Application no: H02-0496-11

Location: Martins Farm
Postland
Crowland
Peterborough
PE6 0JU
PE6 0JU

Amendment: Amended design details (dwg. nos. 300-07-16, -02B, -03A, -04B, -05B, -08A, -09B, -12B, -15A)

Re: Martin's Farm, Postland, Crowland – Your Ref: H02-0496-11 – Conversion of barns into two residential dwellings

Drawing Title:
External Works Layout

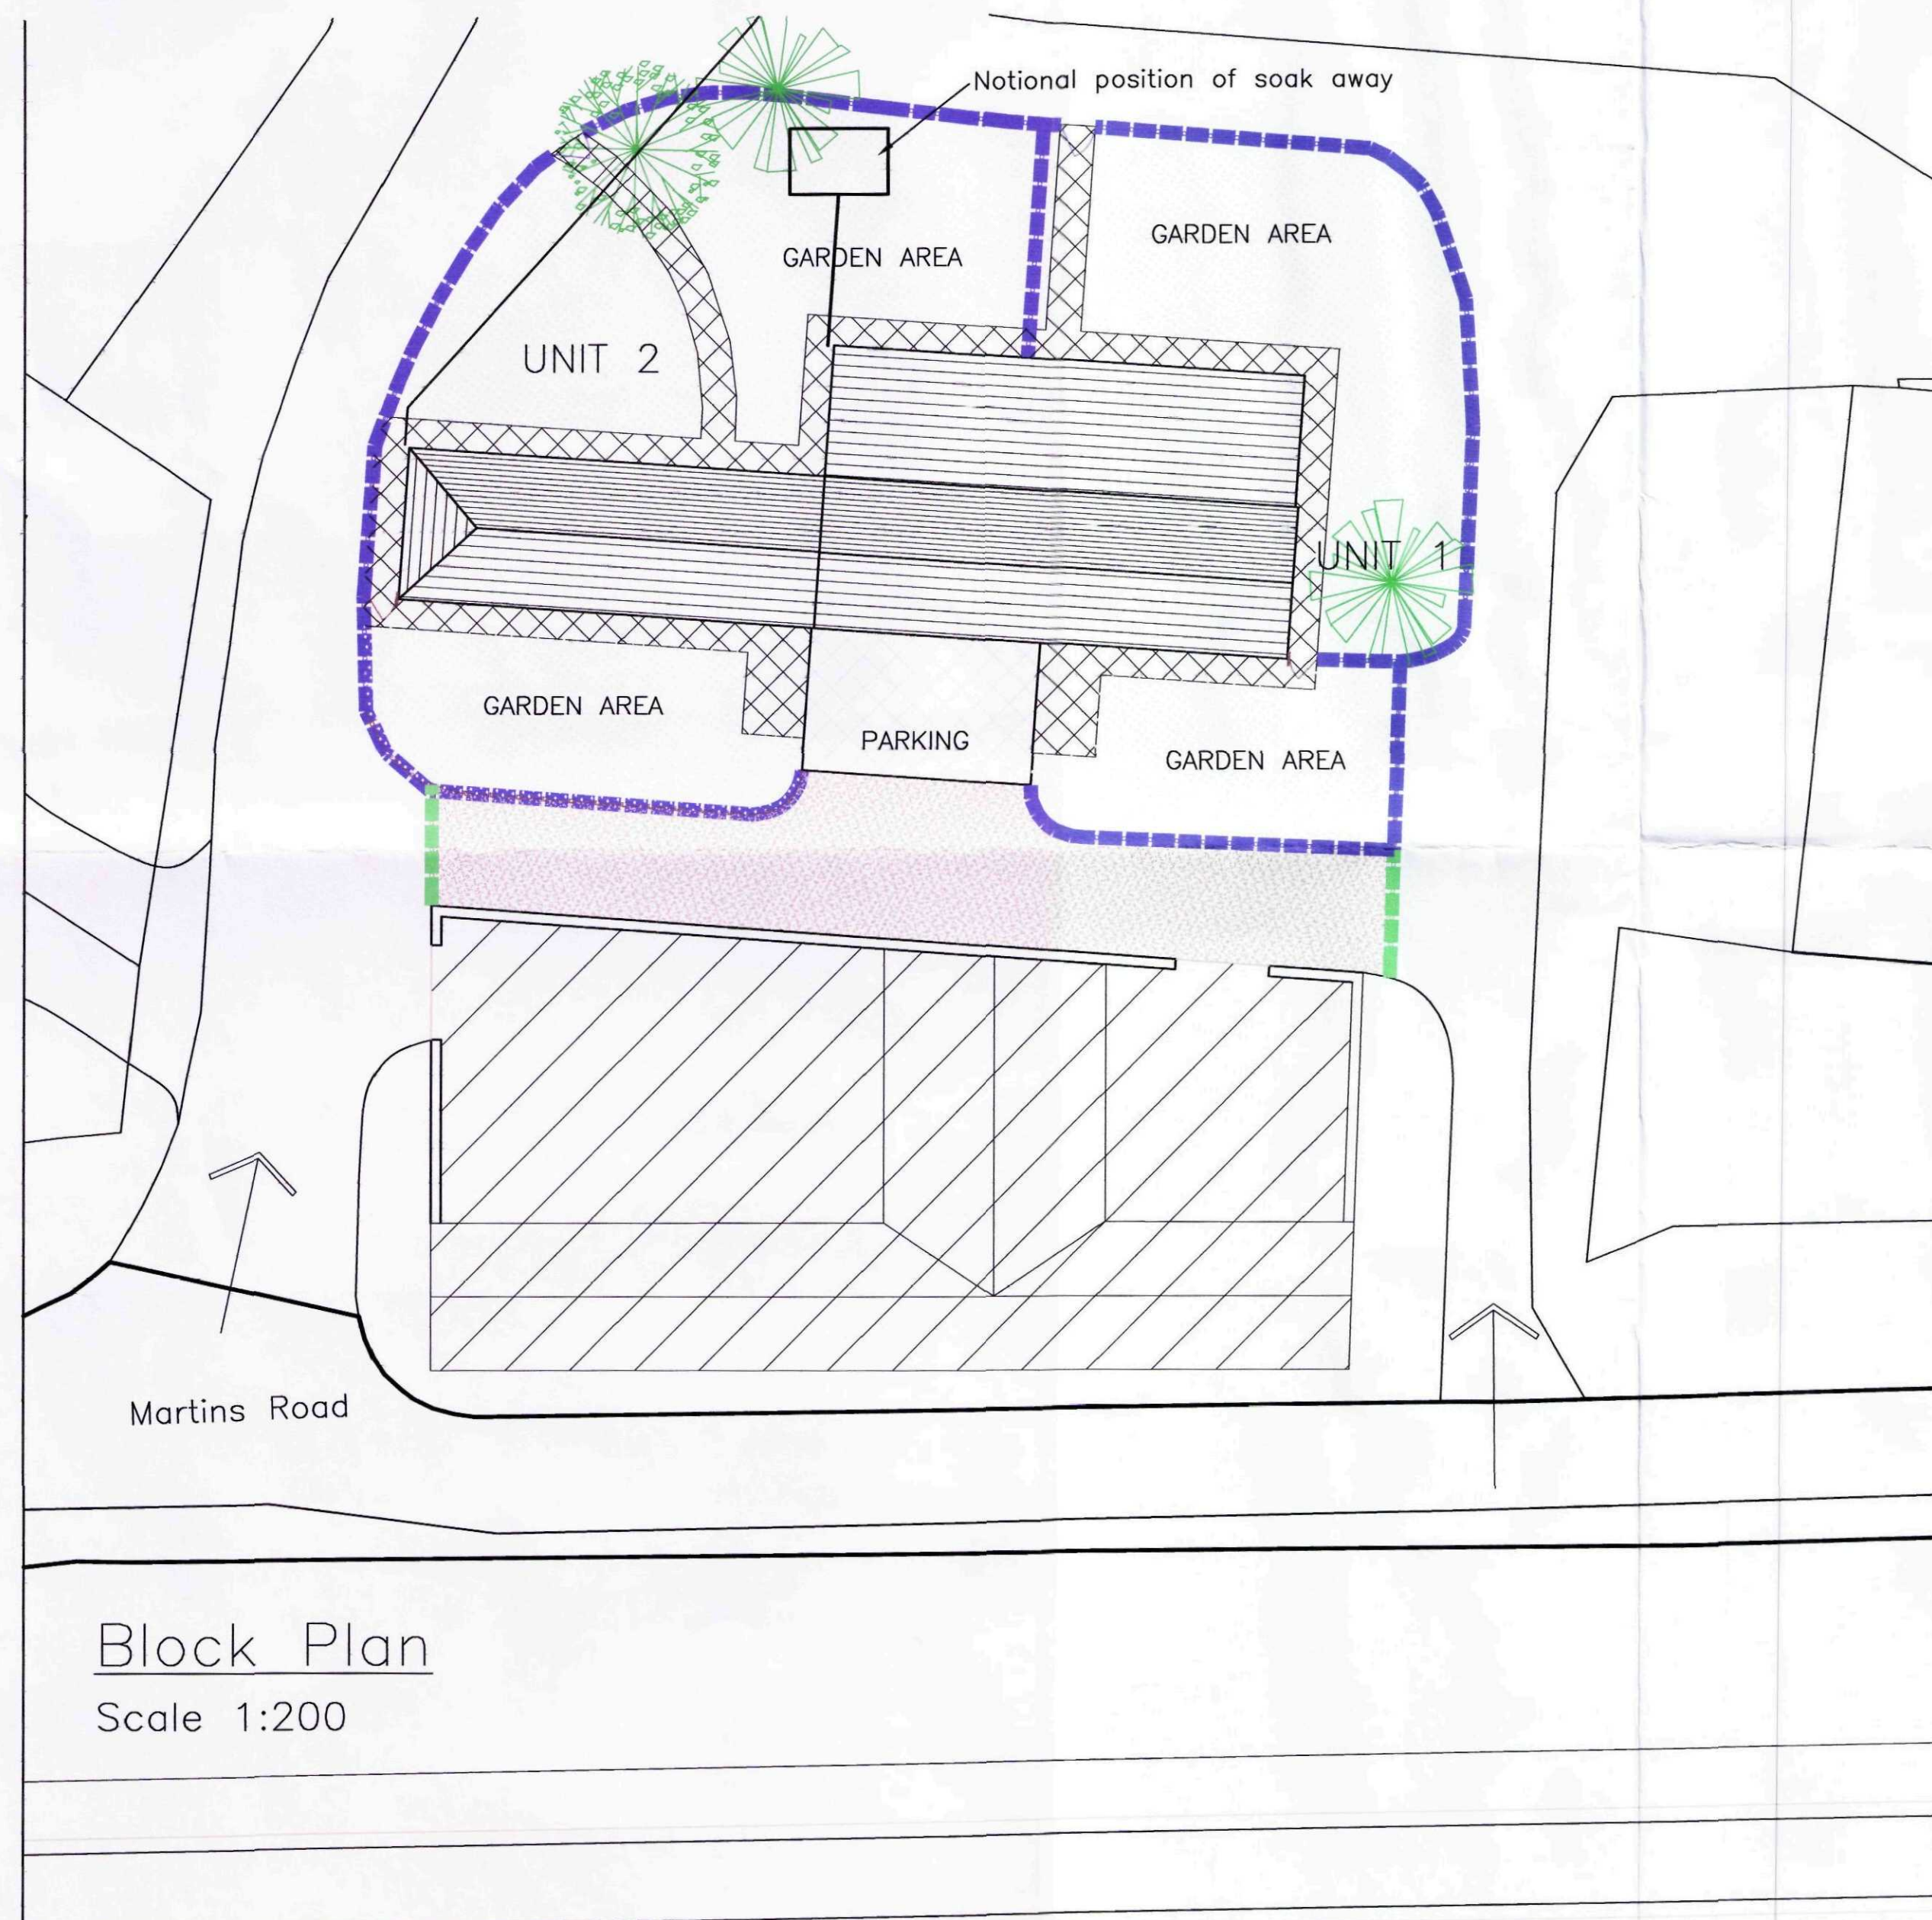
With regard to the boundary treatment please refer to the revised enclosed external works drawing.

Scale: 1:50 Date: 17.01.11
Drawing Title:
Ground & First floor layout
Drawing No.
300-07-02 Revision A

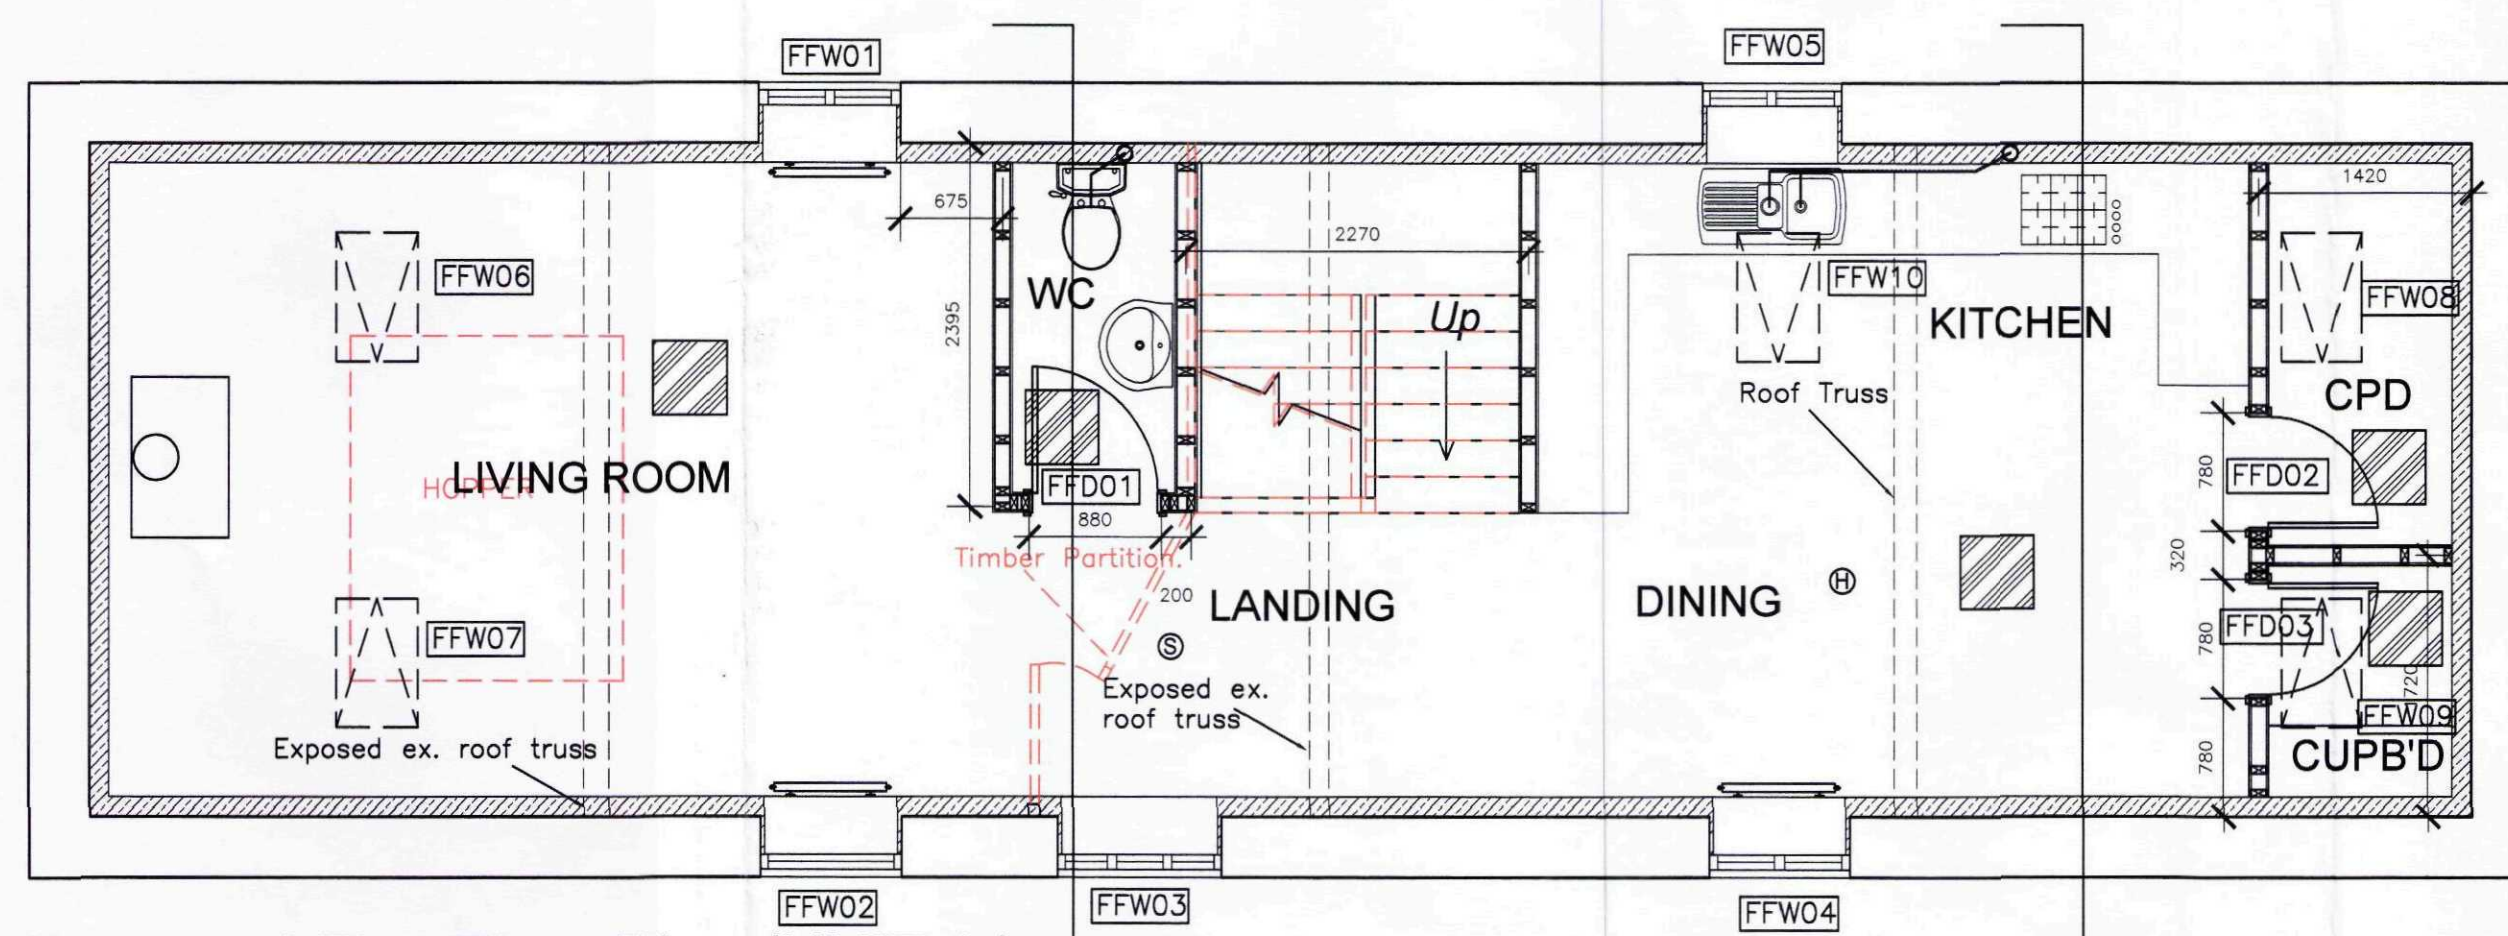
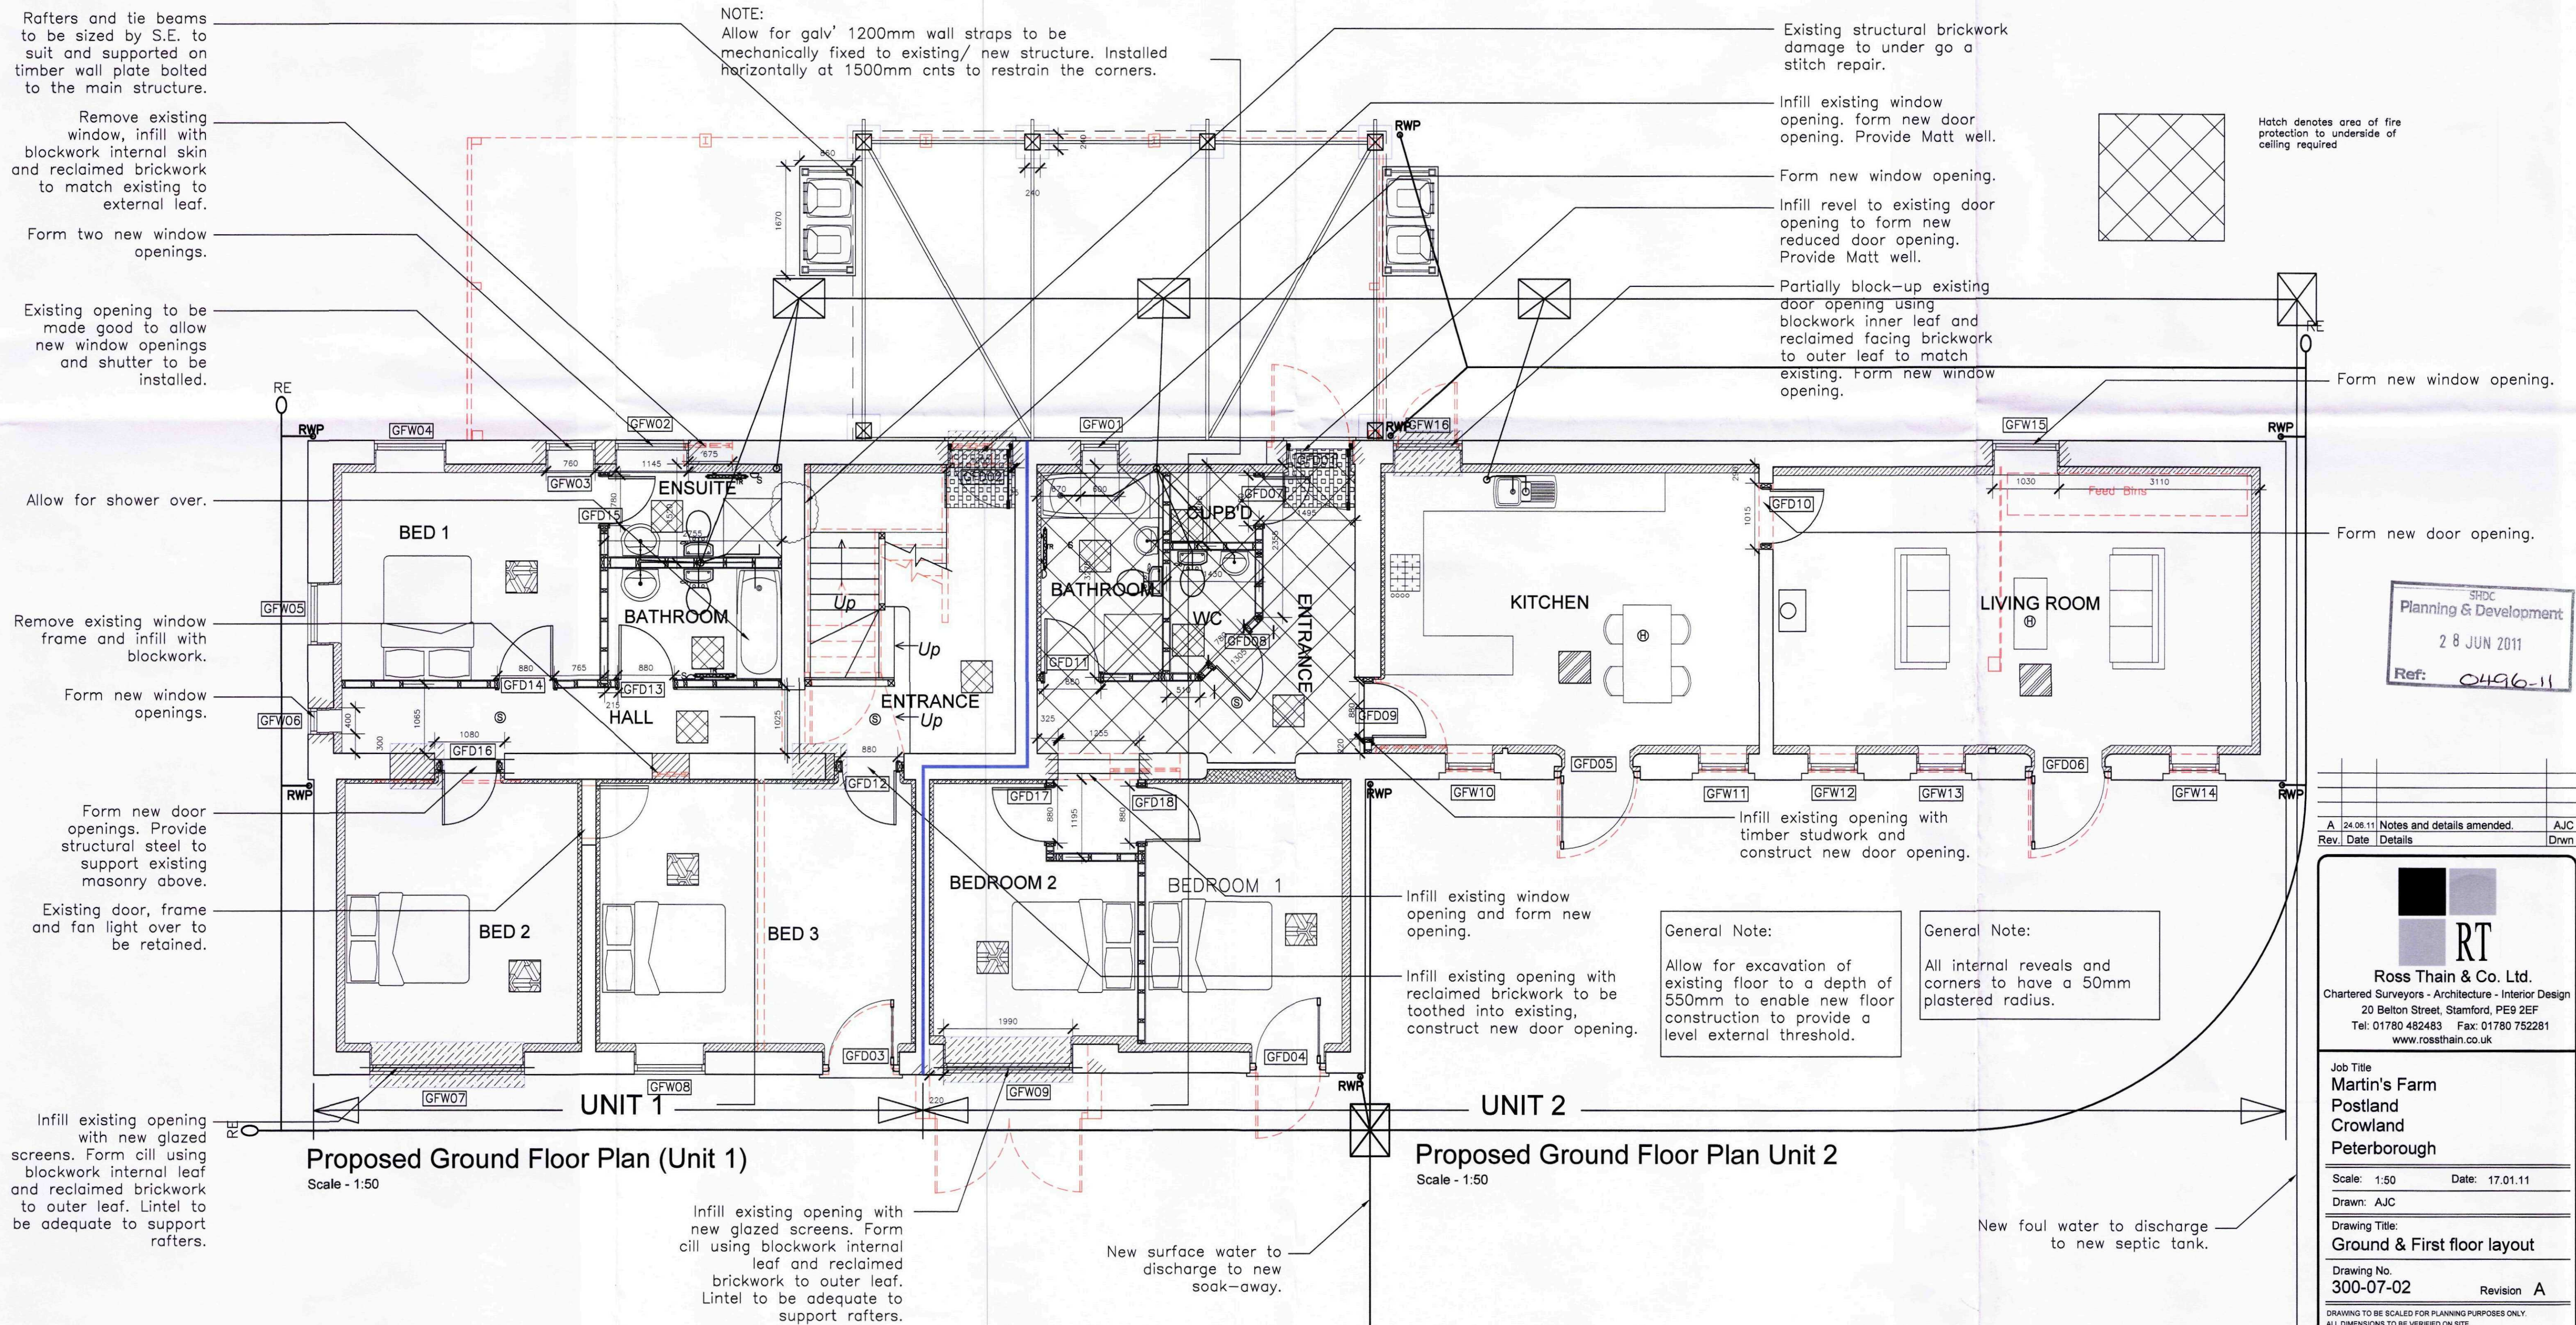
I can confirm that the existing floor boards will be lifted, cleaned and re-laid on the existing joists and overlaid with sound insulation and floor finish, allowing the floor joists and boards to be viewed from the ground floor with the exception of the entrance hall which requires fire protection and separation.

With regard to the excessive areas of internal dry-lining, we have dry-lined all the external walls to enable the properties to become better insulated and to prevent damp permeating through the walls. We felt it necessary to dry-line the existing internal walls only where excessive remedial works and infilling is to be carried out, along with the party wall to increase sound proofing.

As a result of our site meeting I can confirm that the existing staircase will be retained with the exception of the works to the lower portion and remedial works to ensure the staircase is safe along with the relocation of the existing door and frame, all as indicated on the enclosed plan. The previous detail drawing indicating an entirely new staircase is to be discarded.

With regards to internal doorway serving bedroom 3 to unit 1, it is to be retained including fanlight over as indicated on the enclosed drawings.
